Our Ref : EN – N18\_Iglu Redfern\_DPE Issues Letter [Rev 1.0]  
Contact: Vince Nigro

### **SERVICES CONSOLIDATION OF 60-78 REGENT STREET & 80-88 REGENT STREET, REDFERN SITES**

This letter is in response to the DPE Issues Letter and in particular the highlighted text in Item 4, DPE-7 as follows:

Ground Floor Plan

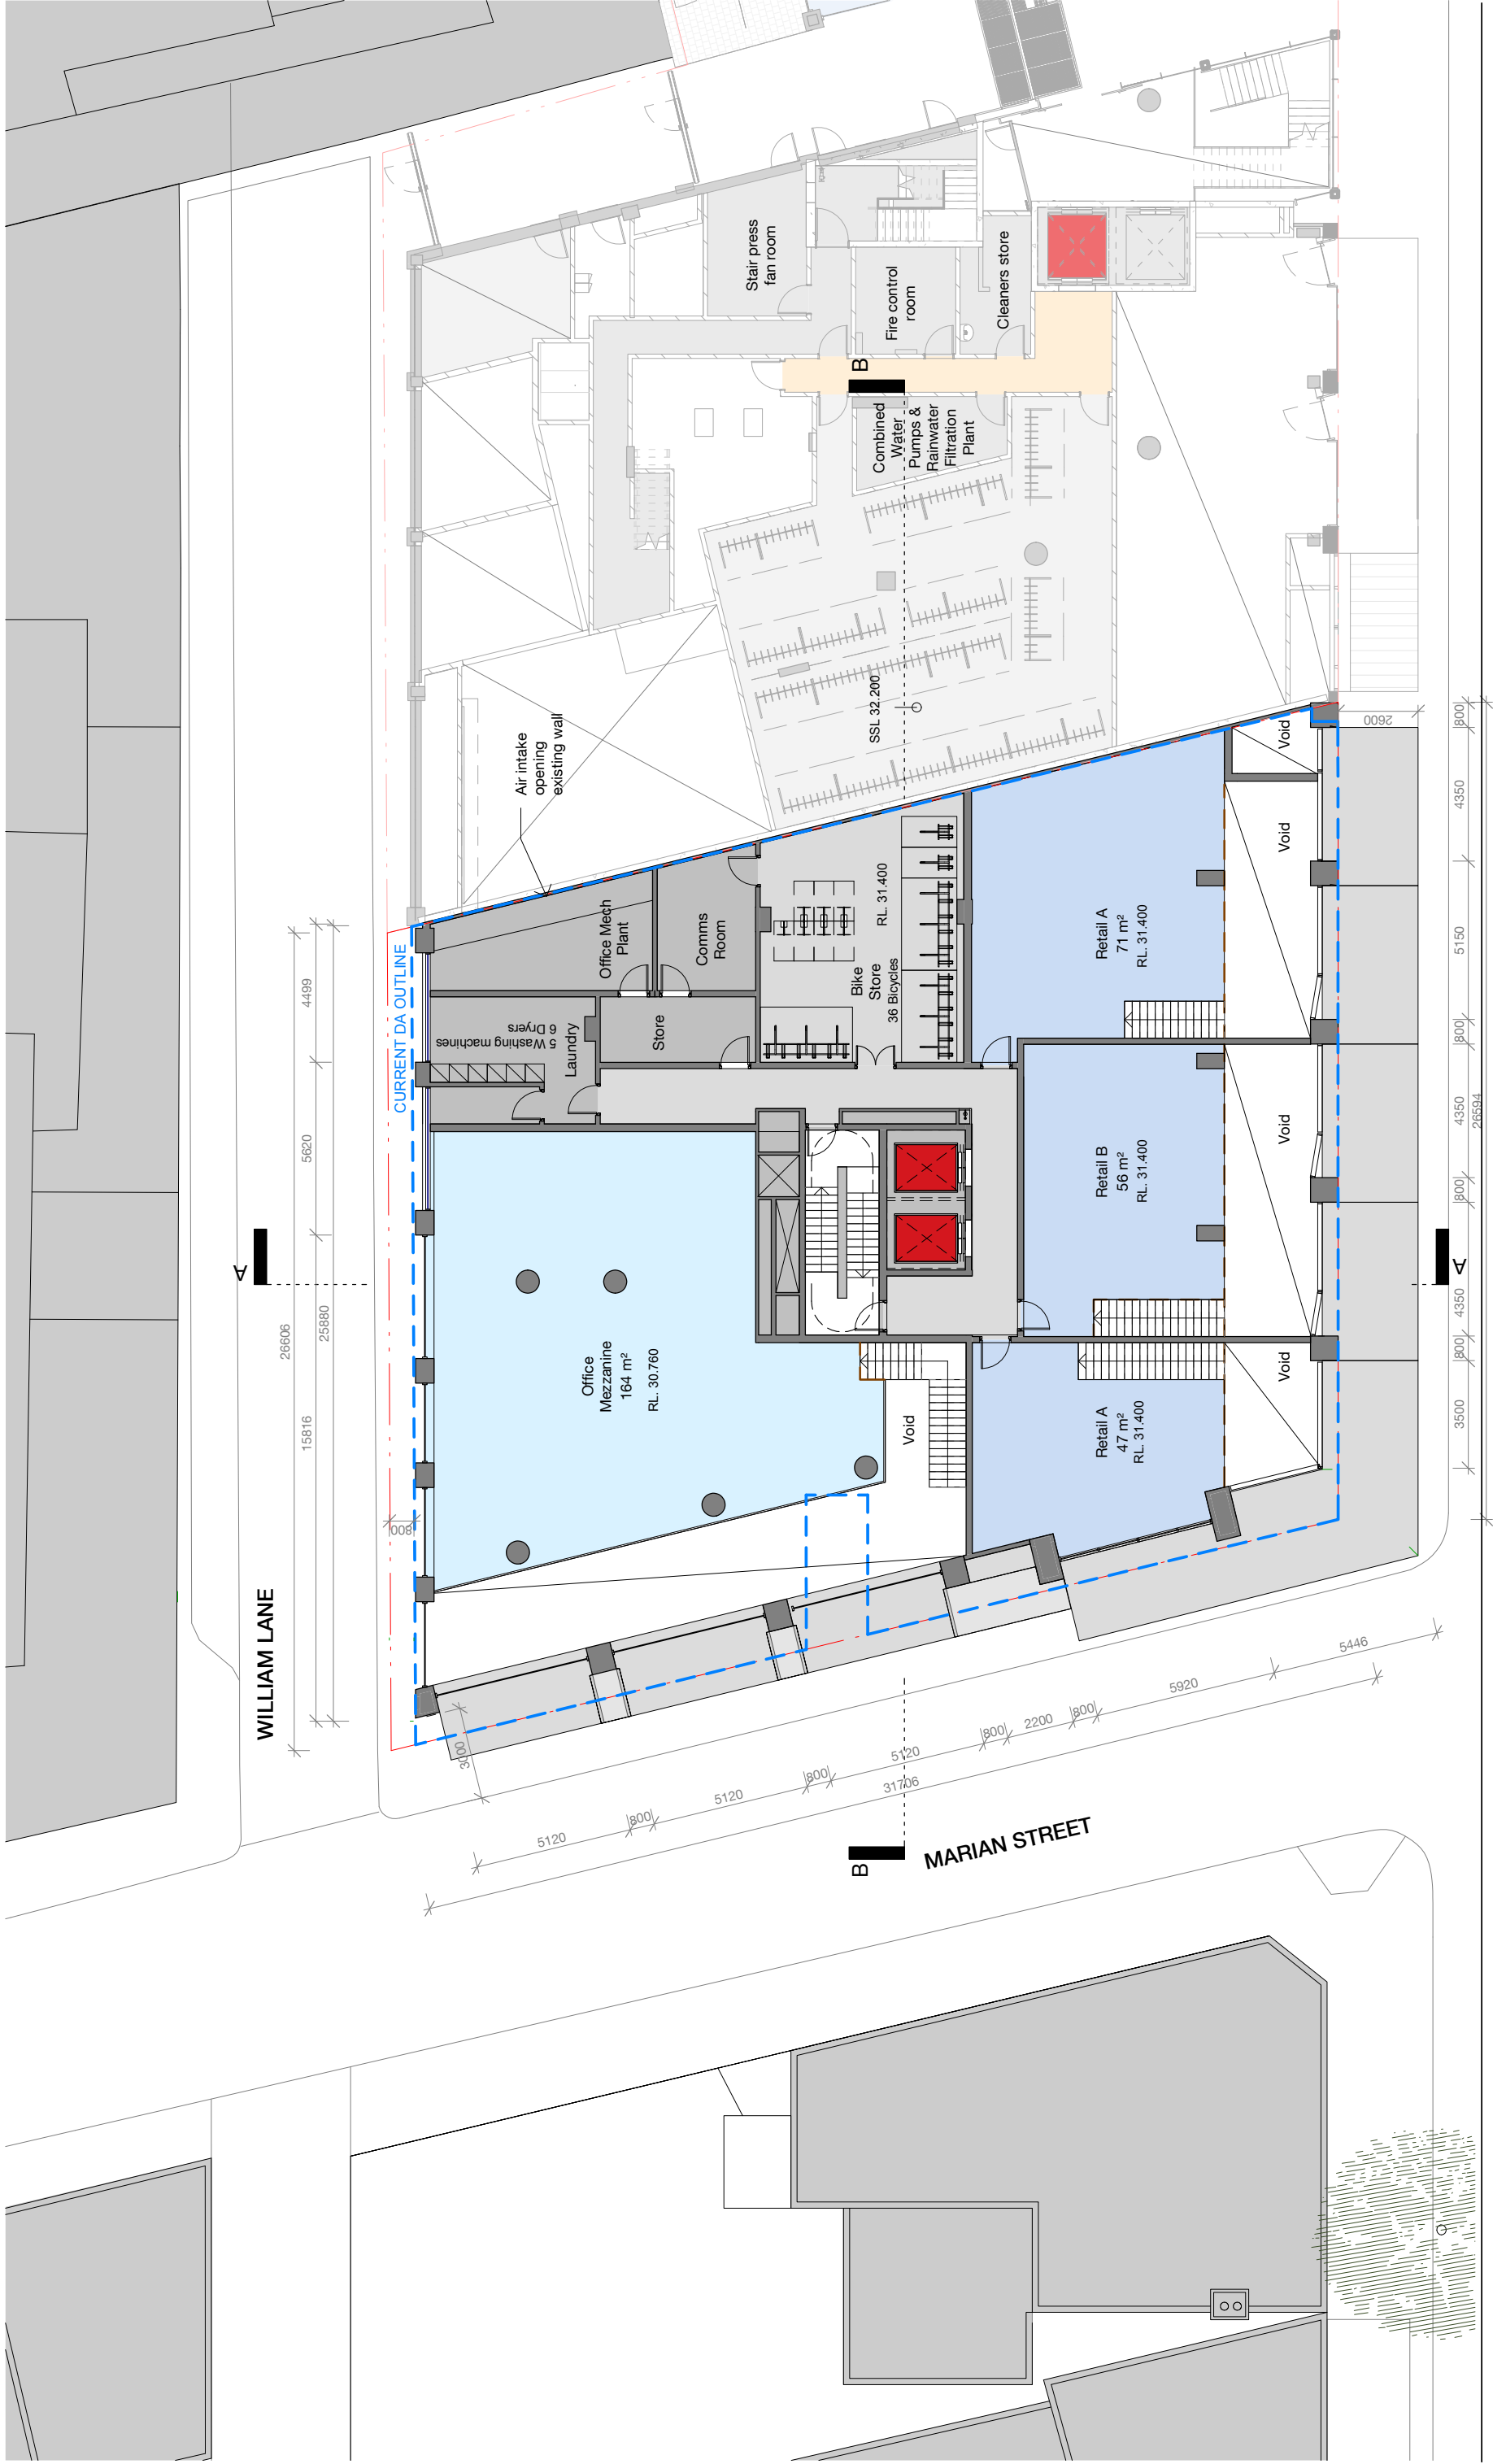
***“Further consideration is required for the ground floor layout, including the following; demonstrate how the level change from the footpath to the retail spaces will be managed demonstrate the location of any required sprinkler and hydrant pump room, tanks, substation, fire control room and/or fan room. It is noted that the development at 60-78 Regent Street resulted in the loss of community room for these services.***

A new main distribution board will be required , fed from the existing main switchboard and this will be housed within a new switchroom located on ground floor.

New communications rooms have been allowed for to cater for the new development and these have been shown on the associated plans.

No additional major equipment, such as fire brigade booster assemblies, pumpsets and mandatory water storage are required, as fire hazard classification and compartmentalisation in the combined development will be within same parameters as the existing Iglu development.
